**WELWYN HATFIELD BOROUGH COUNCIL – DEVELOPMENT MANAGEMENT
DELEGATED REPORT**

APPLICATION No:	W6/2012/2653/EM
APPLICATION Site:	35 Sherrardspark Road WGC

DESCRIPTION OF PROPOSAL: Loft conversion with dormer window and insertion of window on front elevation of property.

PROJECT	35 Sherrards Park Road
DRAWING TITLE	Proposed Floor Plans REVISIOND
STATUS	Pre - Planning
SCALE 1:100 @ A3	DRAWN BY AM 08 - 005PD

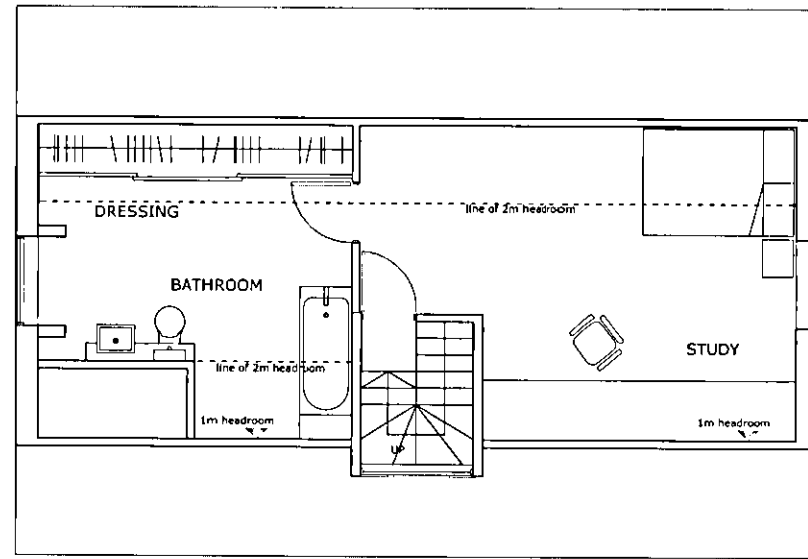
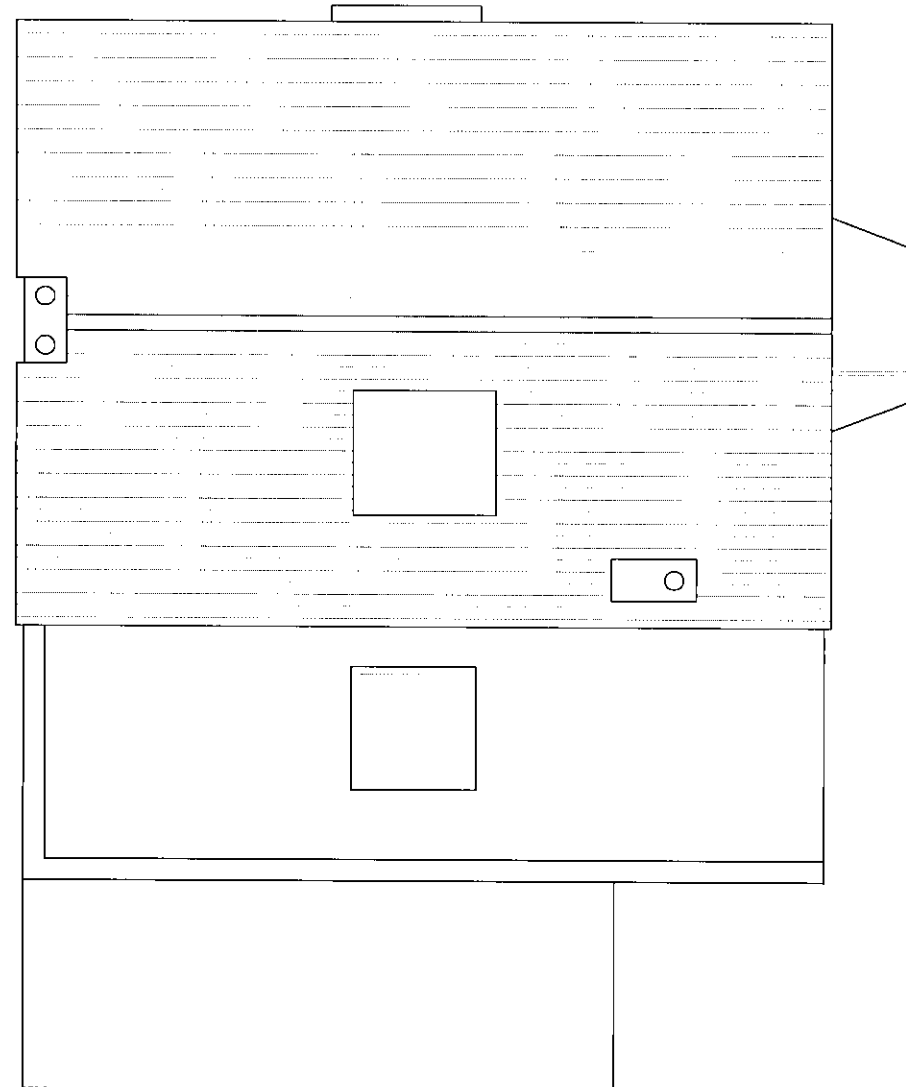
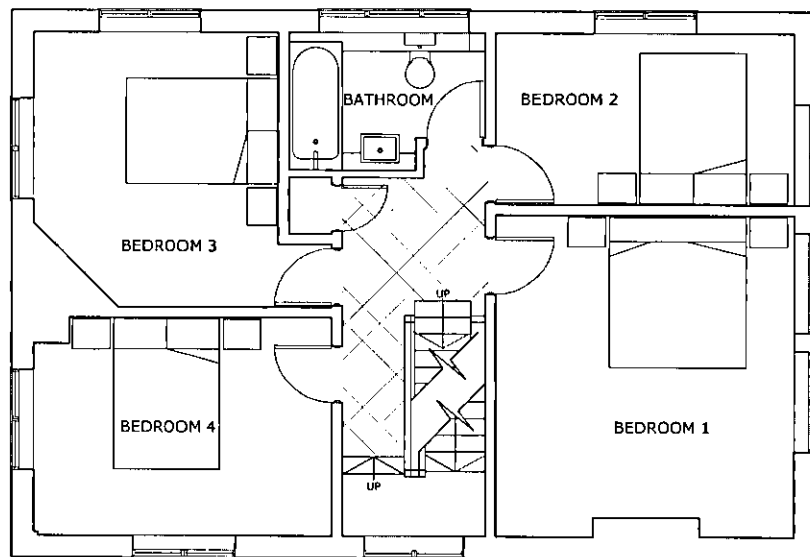
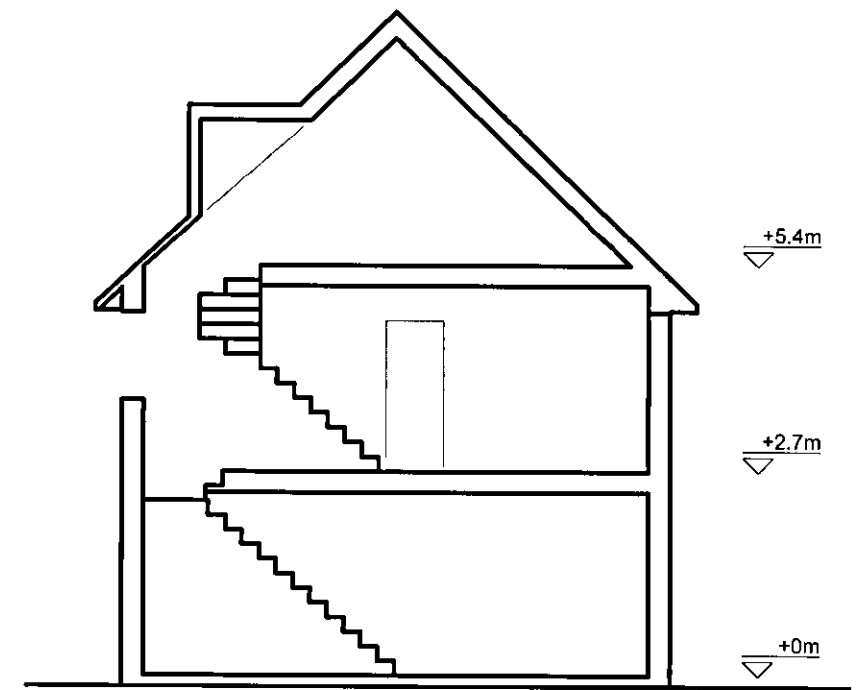
- The proposed design has retained the internal layout at the expense of the external design.

The proposed extensions would insert a new dormer on the existing roof slope on the south west elevation. This new dormer will be for a new staircase which is required to facilitate the conversion of the loft space at second floor level into habitable accommodation.

6. C.13.1: The development/works shall not be started and completed other than in accordance with 08-001P & 08-005PD & 08-004PD received and dated 19 December 2012

PROJECT	35 Sherrards Park Road	AMA DESIGN
DRAWING TITLE	Proposed Elevations REVISION D	
STATUS	Pre - Planning	
SCALE 1:100 @ A3	DRAWN BY AM 08 - 004PD

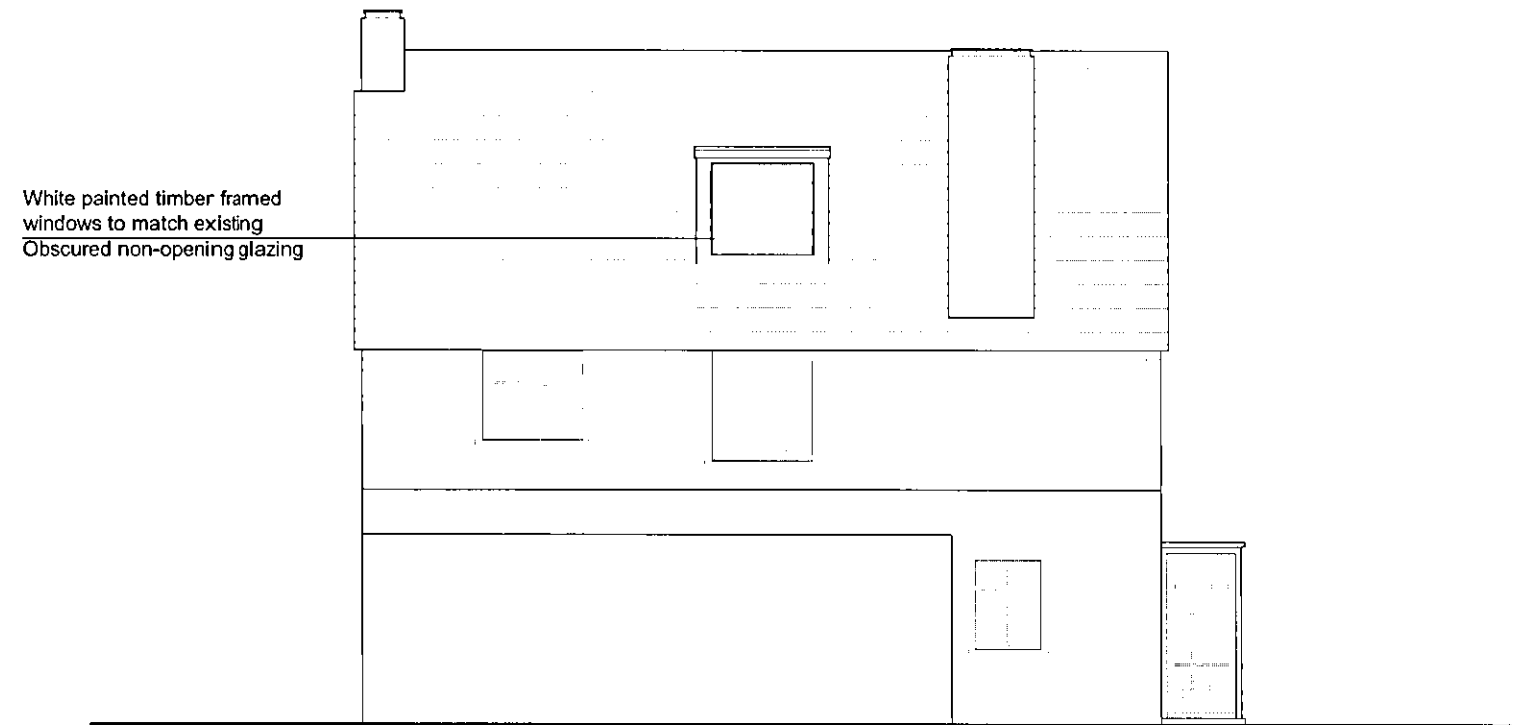
- The photograph on the D&A is not the side of the roof where the dormer is proposed
- The Design Statement refers to 9 other second floor dormers in the area, but 6 of these are on the front elevation and so not comparable. They also do not affect other properties privacy.

- The proposed dormer is not considered to preserve or enhance the character and appearance of the Conservation Area as it is highly visible and far larger than the other examples.

The design of the dormer will have a lead formed flat roof and leaded dormer checks. The window will be white painted timber to match the existing windows. The Georgian glazed windows panes are of similar proportions to the original windows of the property. The proposed dormer window is also aligned centrally with the first floor window below.

The issue here, however, is not primarily that the dormer can be seen from the streetscene, as this is more apparent on the dormers which exist on the front elevations of other properties, but that the dormer will in effect appear as a side dormer which will be directed towards the side of No.37.

In regards to the proposed second floor gable end window, this would be on the elevation facing onto Sherrardspark Road. There is an existing gable end window which is on the elevation facing onto the main garden area of the dwelling which is of a similar design, but slightly smaller. This is considered to reflect the character of the dwelling and would not harm the appearance of the wider area. It is proposed to use white painted timber to match the existing windows and this is acceptable subject to a condition.

There is a requirement therefore to ensure that the residential amenity of No.37 is not materially affected through the potential of loss of privacy through the design of the dormer. The proposed dormer is centrally located within the roofslope of the application property which means that it will be orientated towards the existing side roofslope of No.37. Direct views will be limited therefore towards the gable end of No.37, although there will be some potential for overlooking to the rear of No.37 from more oblique angles.

The applicant has agreed to have the dormer window obscure glazed and non opening. Such design proposals would ensure that any overlooking that may be possible to towards No.37 would be prevented.

7. The dormer hereby permitted shall be constructed with a lead flat roof and dormer cheeks and with a white painted timber framed window. The second floor gable end window hereby permitted shall be constructed with white painted timber framed window. These approved materials shall not be changed without the prior written consent of the Local Planning Authority.

8. The second floor dormer of the proposed extension hereby permitted shall be glazed with obscured glass and shall be fixed so as to be incapable of being opened and shall be retained in that form thereafter.
